re: **Response to City Comments - Grading Plan Review**
Proposed Commercial Development
2390 Stevenage Drive - Ottawa

file: PG4583-MEMO.01

Grading Plan Review

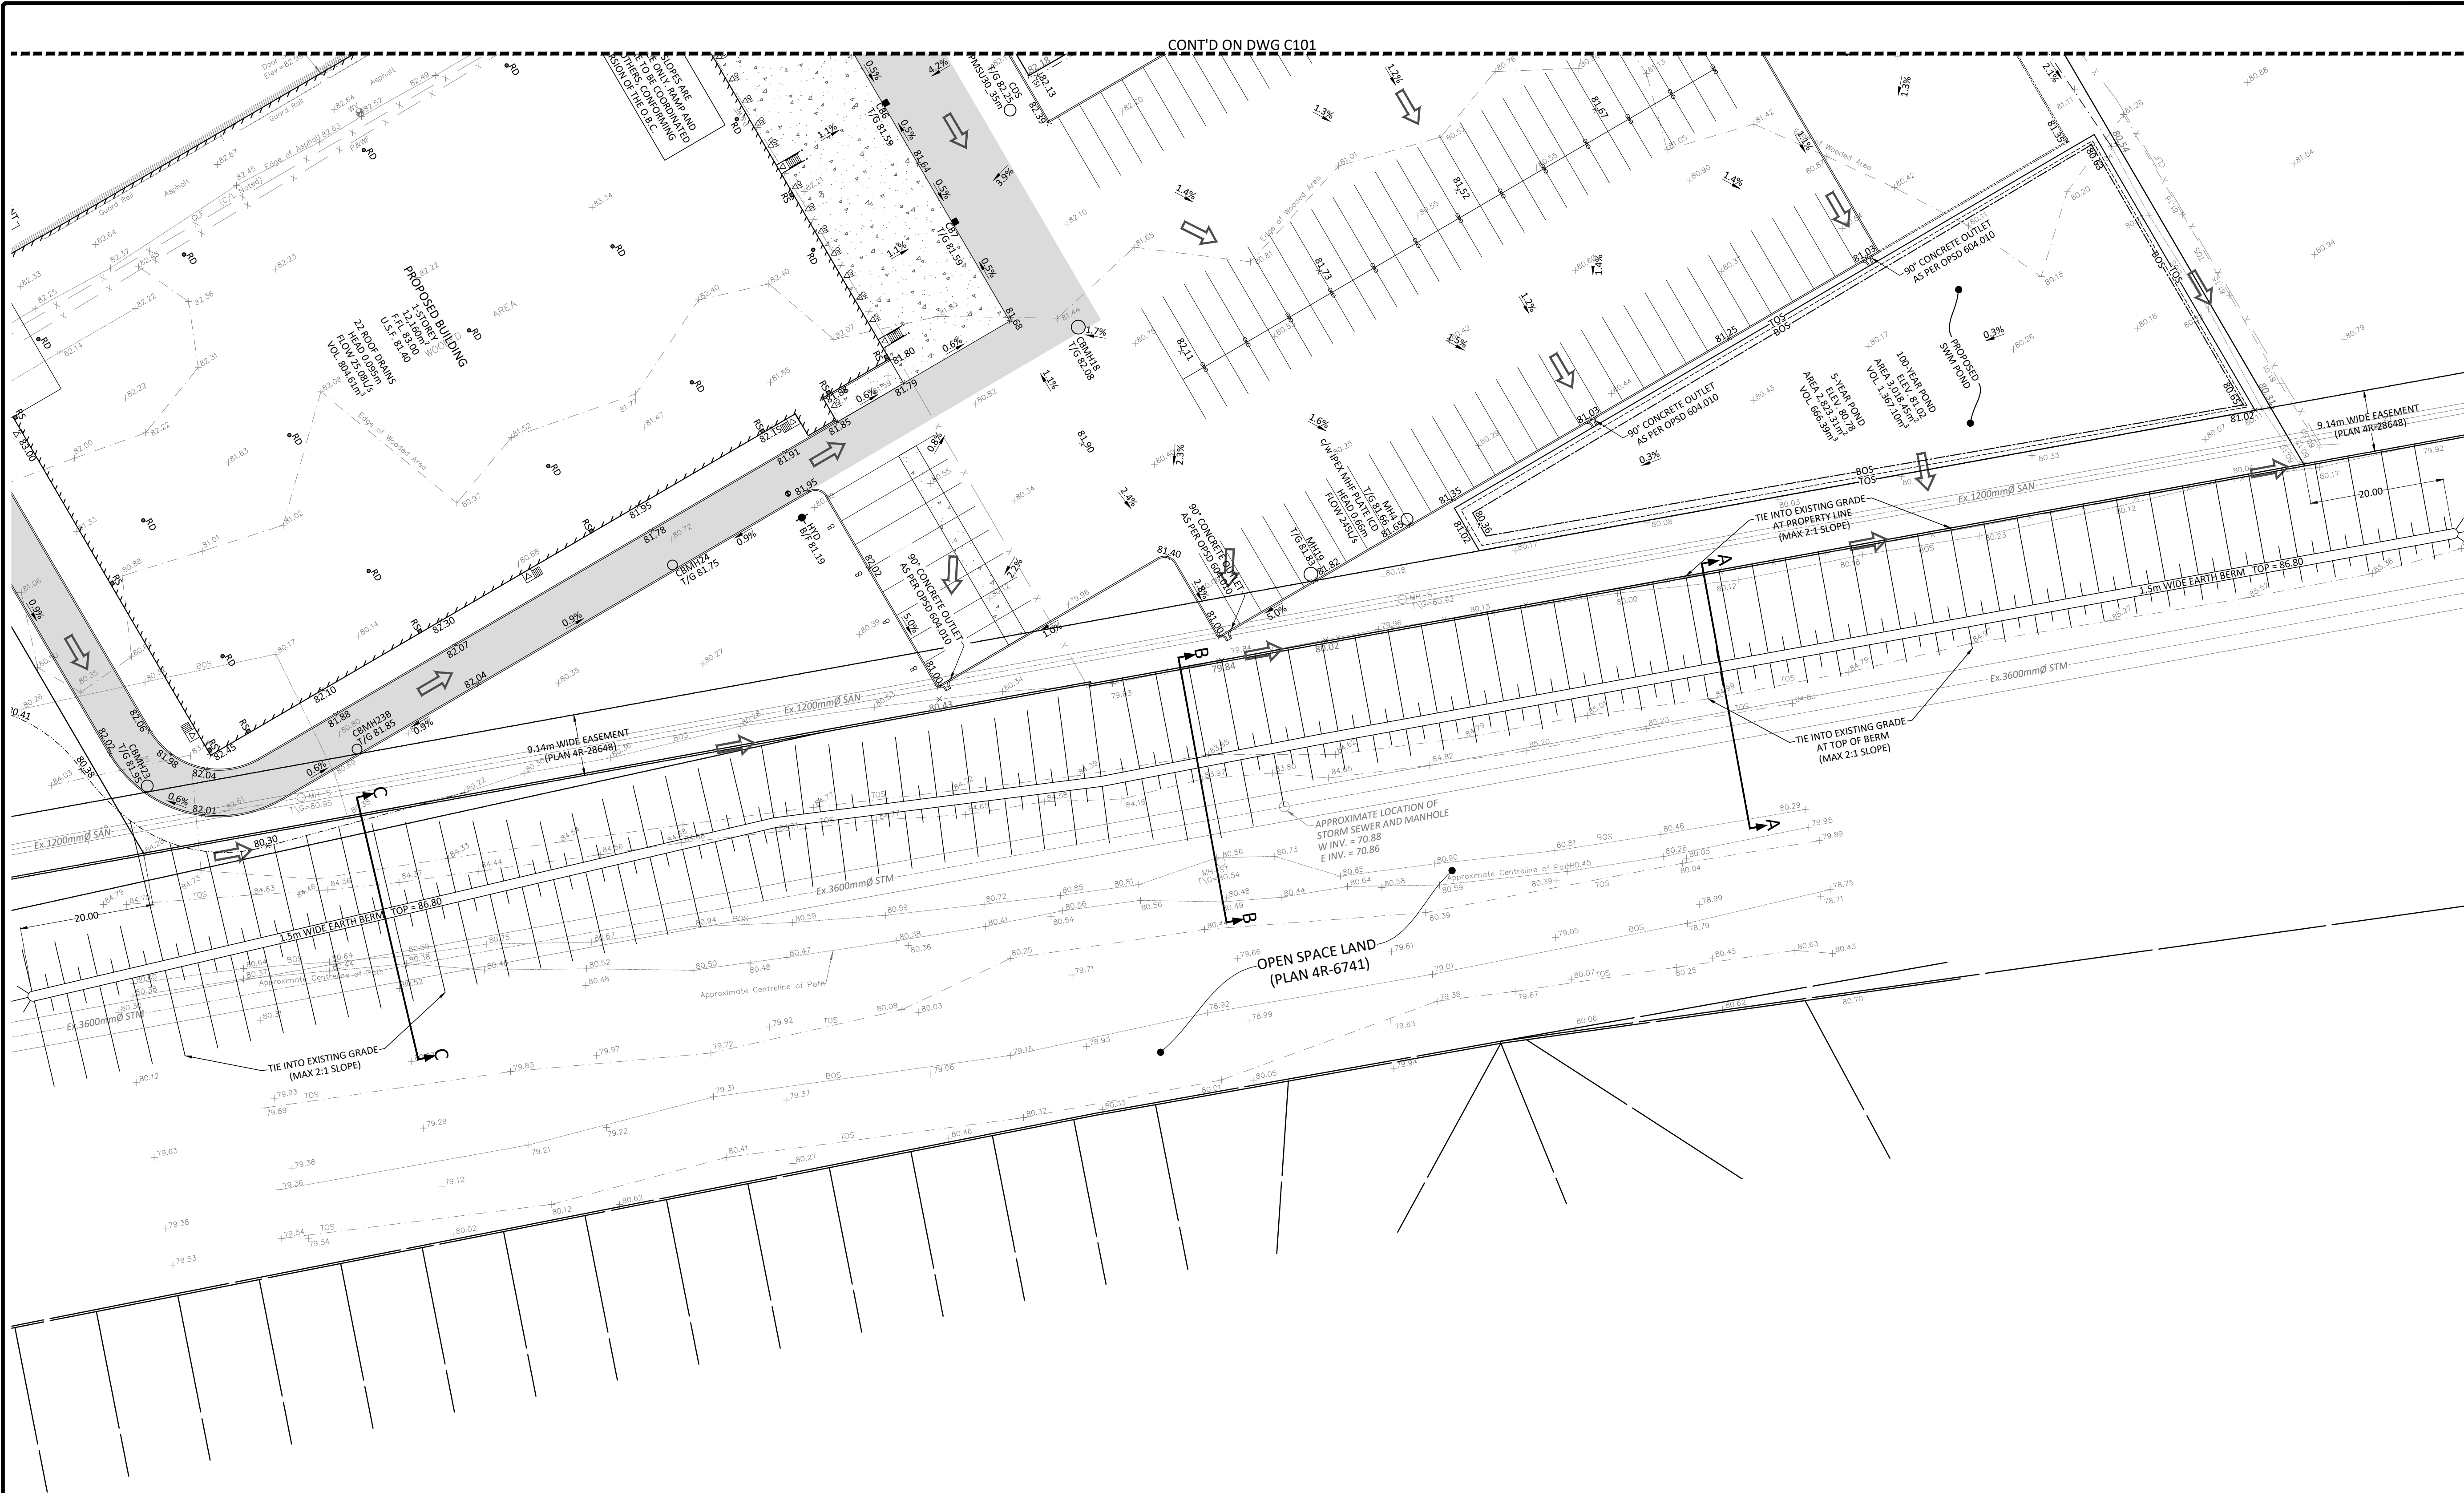
- Site Grading and Drainage Plan - Drawing No. C101 - Project CP-18-0170 - Revision 2 dated January 10, 2019.

Based on our review, the proposed grades are in conformance with our permissible grade raise recommendations provided in the above noted geotechnical report and are acceptable from a geotechnical perspective. Therefore, no lightweight fill is required at the subject site.
